**CITY OF PORTLAND, MAINE  
MEMORANDUM**

**TO:** Richard Knowland, Senior Planner  
**FROM:** James Seymour, Acting Development Review Coordinator  
**DATE:** July 1, 1996  
**RE:** Cumberland Avenue Parking Garage Site Plan - August Corp.

I have reviewed the plans and details associated with the site plan application for the Cumberland Avenue Parking Garage by August Corporation and provide the following comments:

A1.2

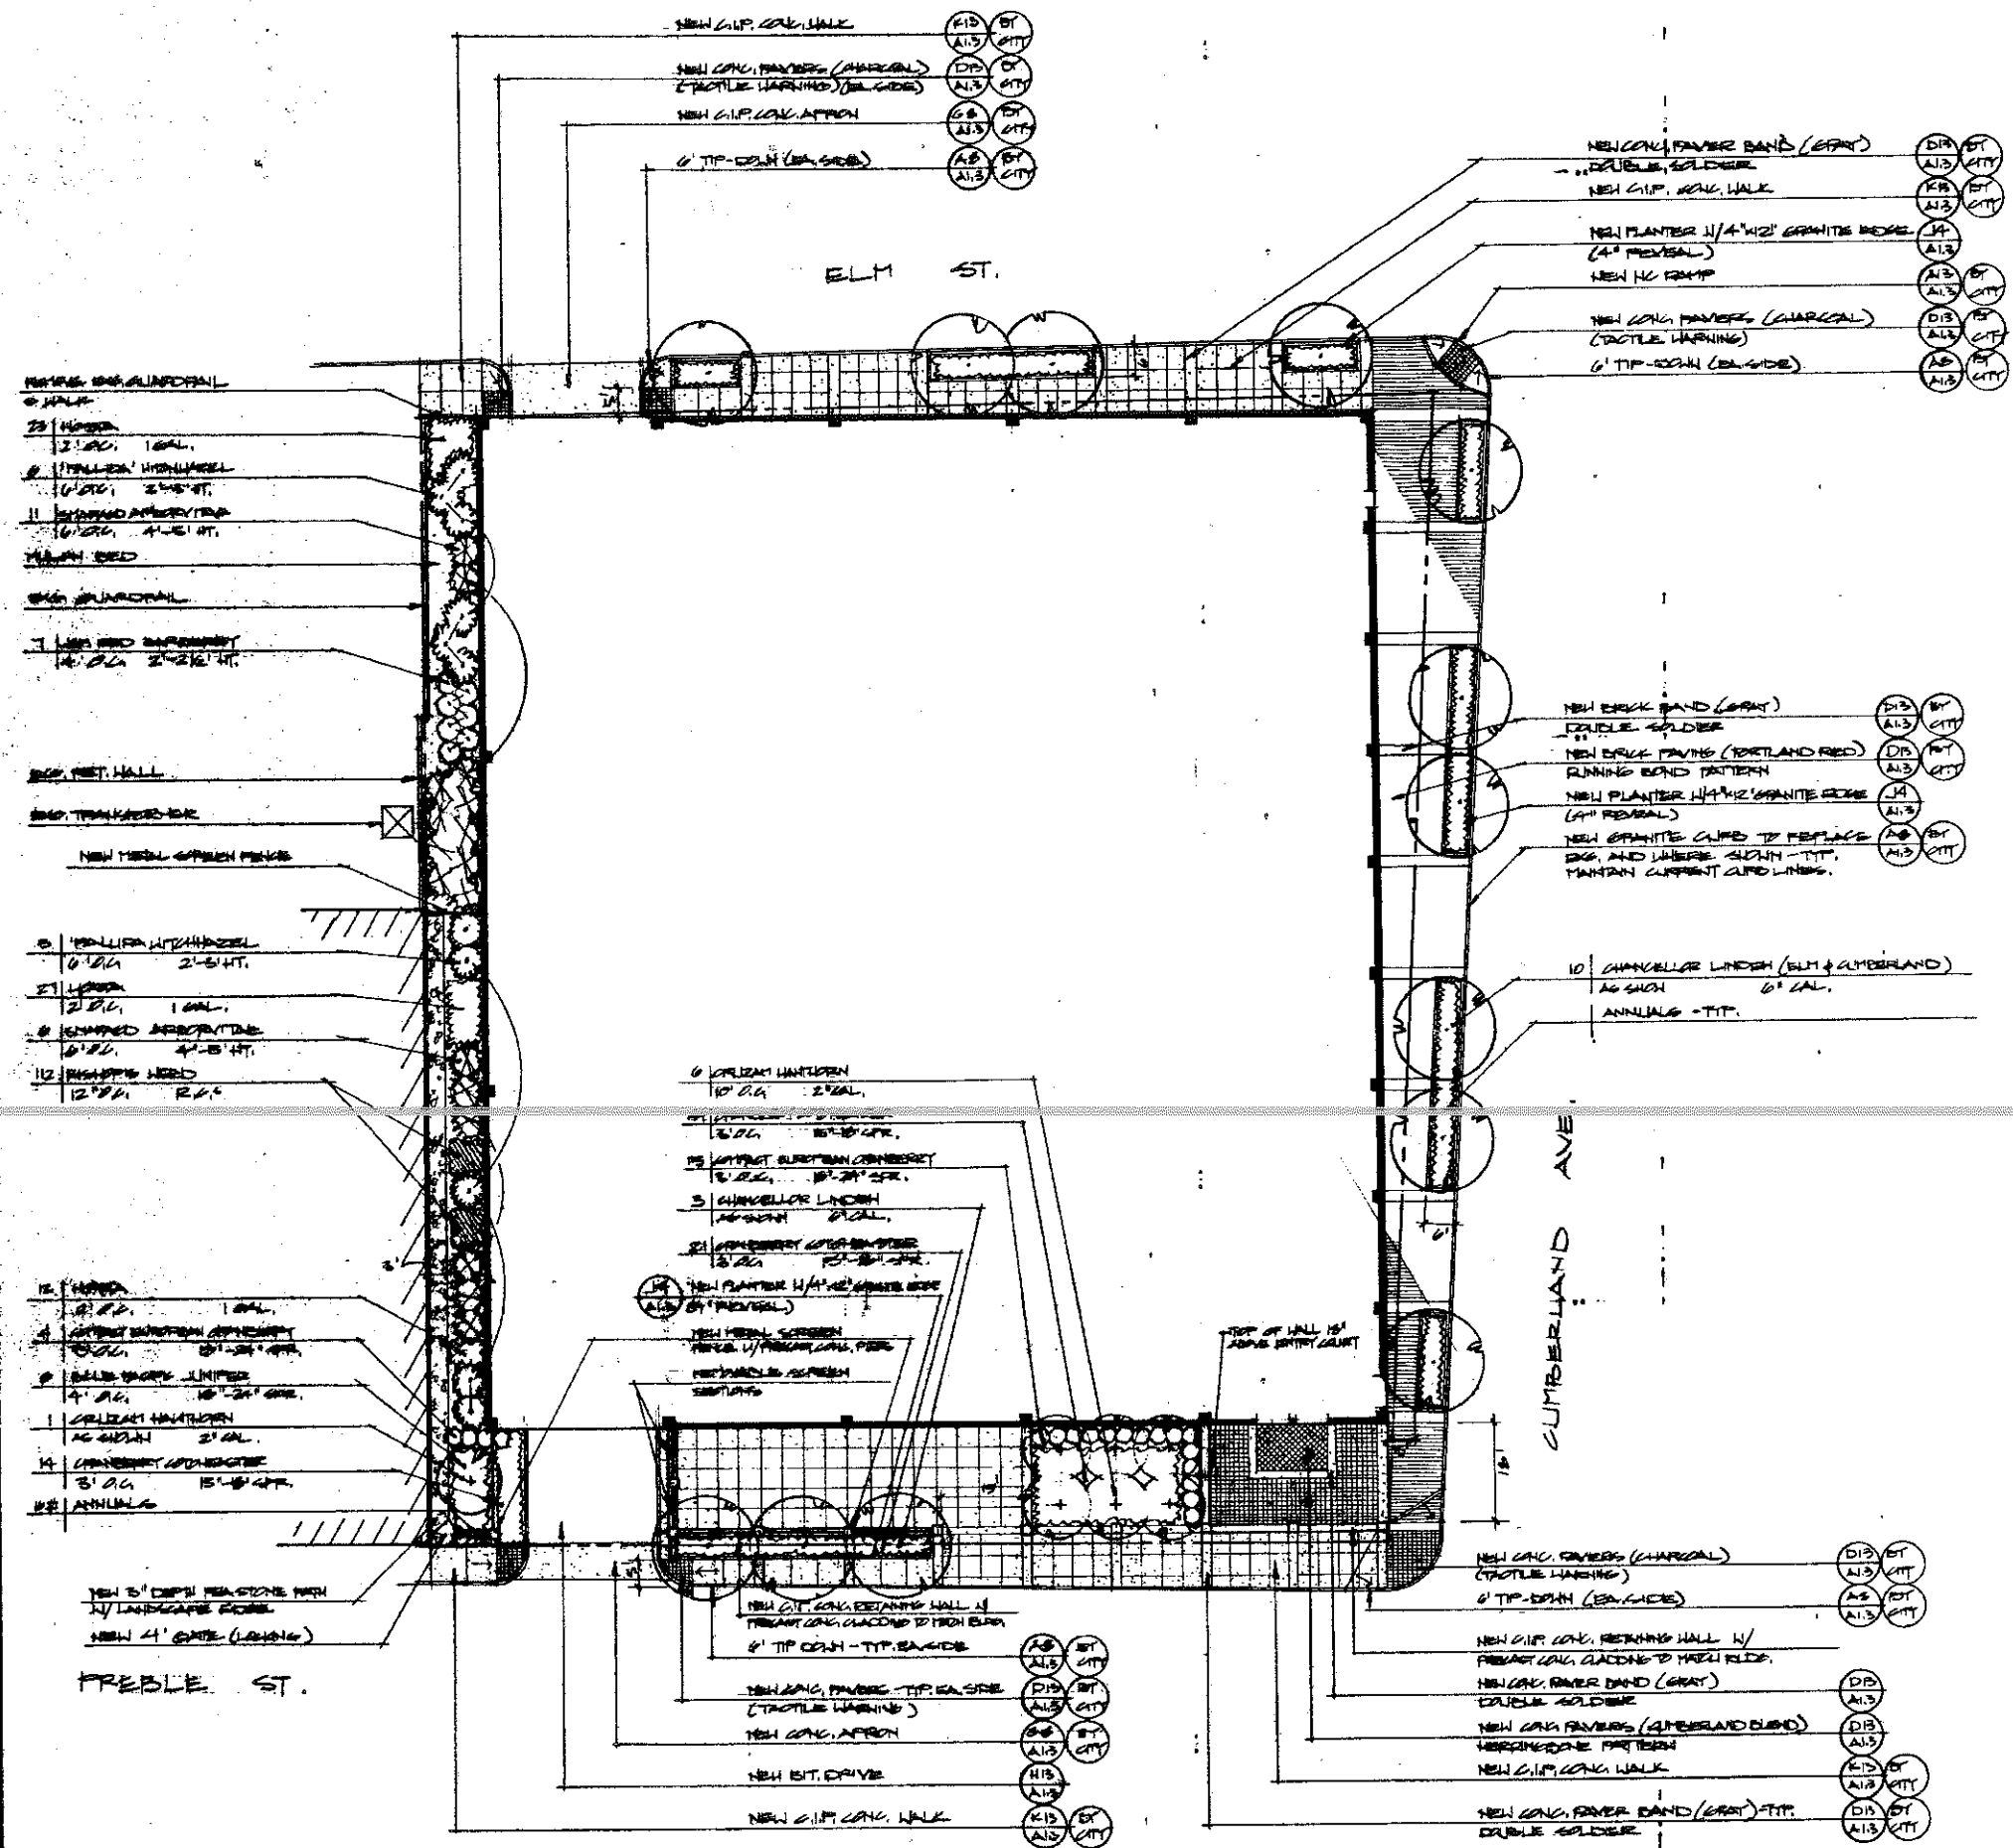
A. The handicap ramp and sidewalk corners as shown on the plan at the location of Elm Street and Cumberland Avenue should not be designed with curved tipdowns. Instead the ramp shall be designed the same as the ramp on the corner of Preble Street and Cumberland Avenue.

*Change  
SEE SHEET  
A1.2*

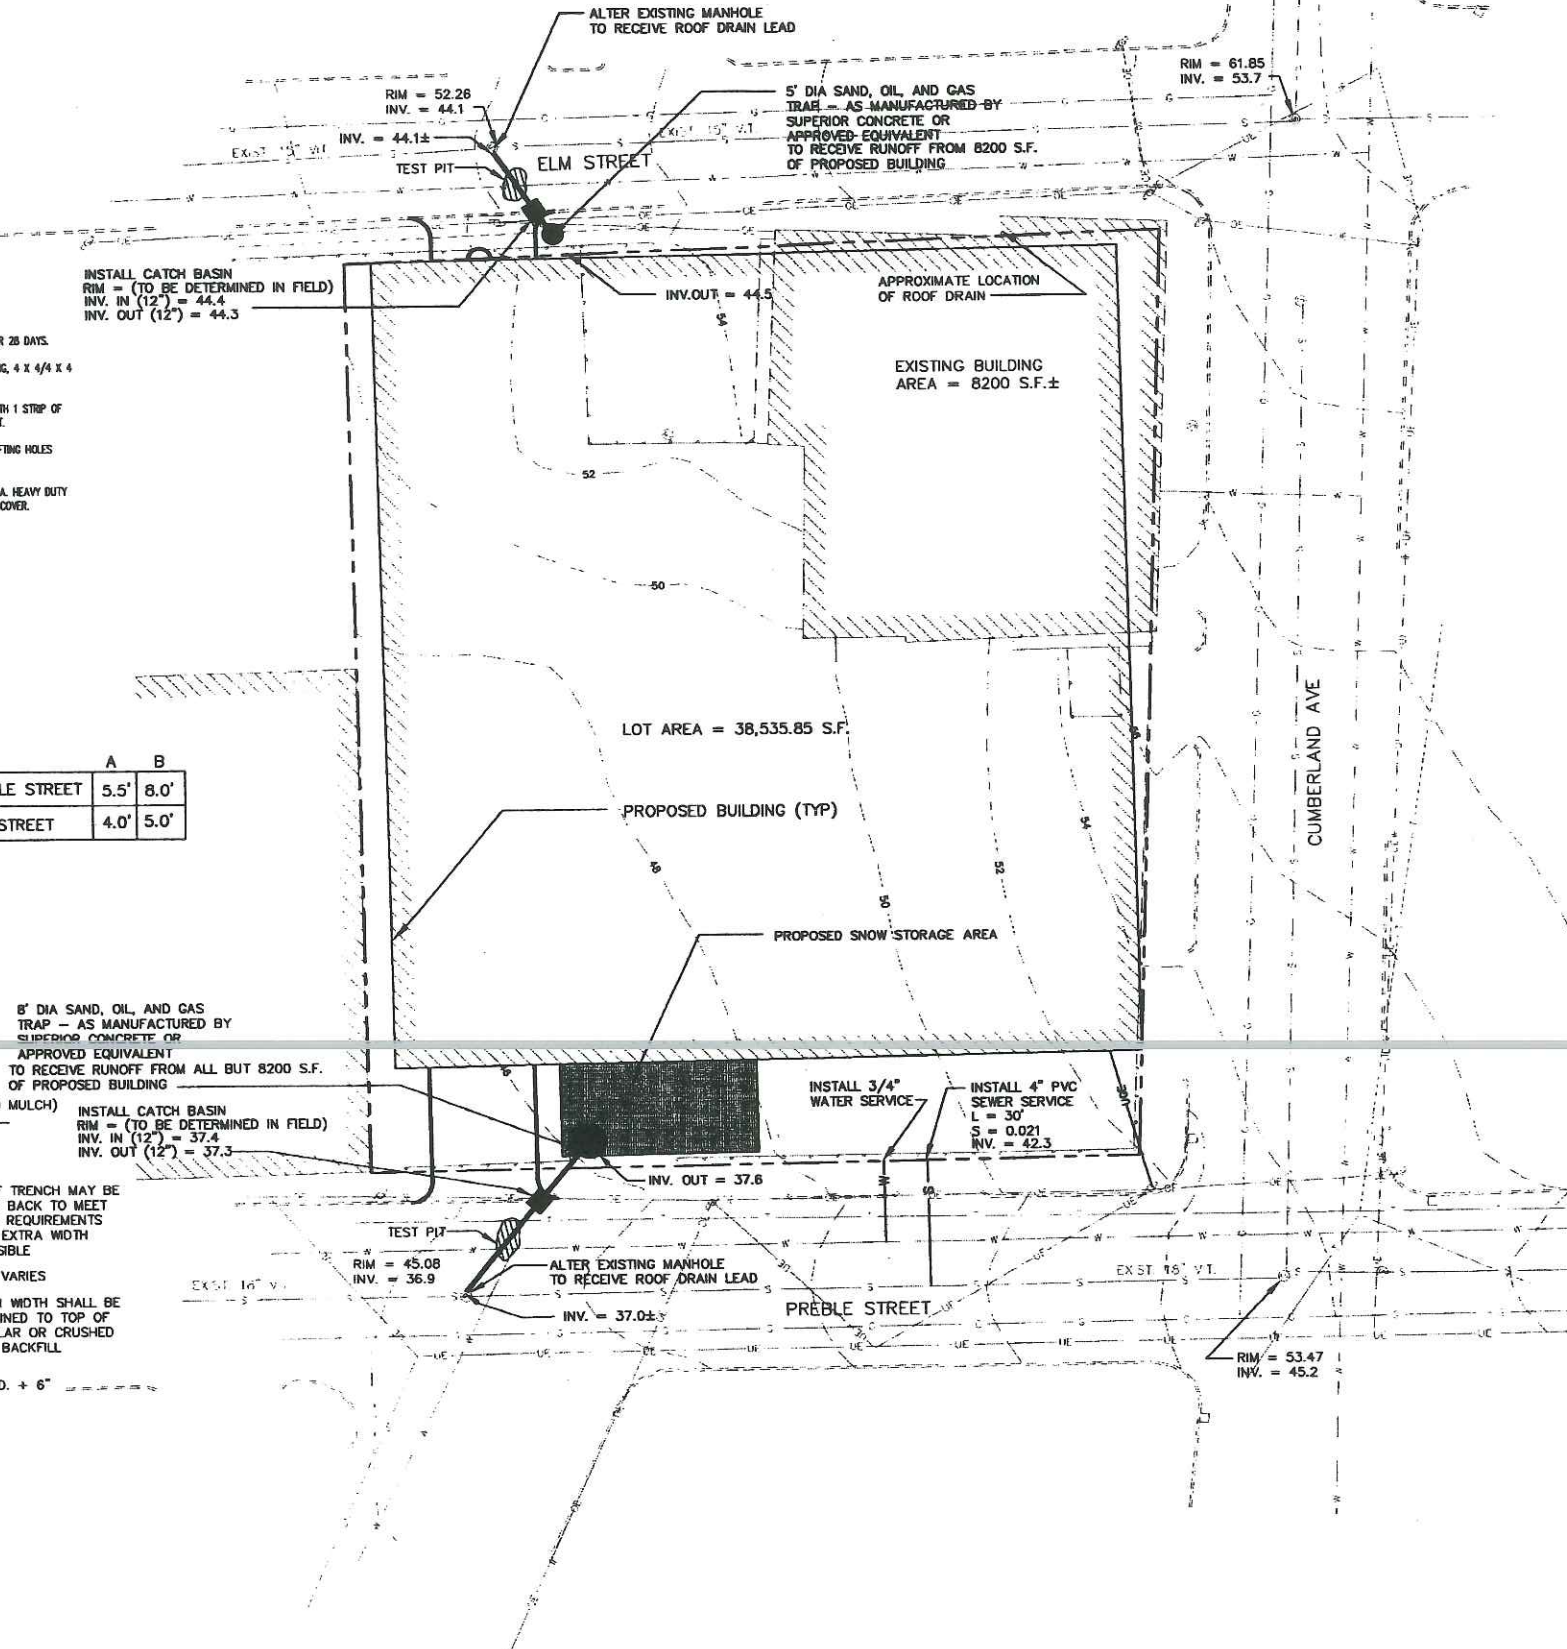
A. The locations of the street catchbasins shall be further away from the handicap ramps such that standard catchbasin inlet "headstone" can be installed.

C. A catchbasin was to be added in the area designated for snow storage. No catchbasin was indicated on the plan. I've spoken with the consultant who may modify the larger 8' oil/grit separator to also function as a catch basin. A detail of the modification or the additional catchbasin shall be added to the Drainage Plan.

*Change  
Preble St  
- CB  
SEE ATTACHED  
SHEET*
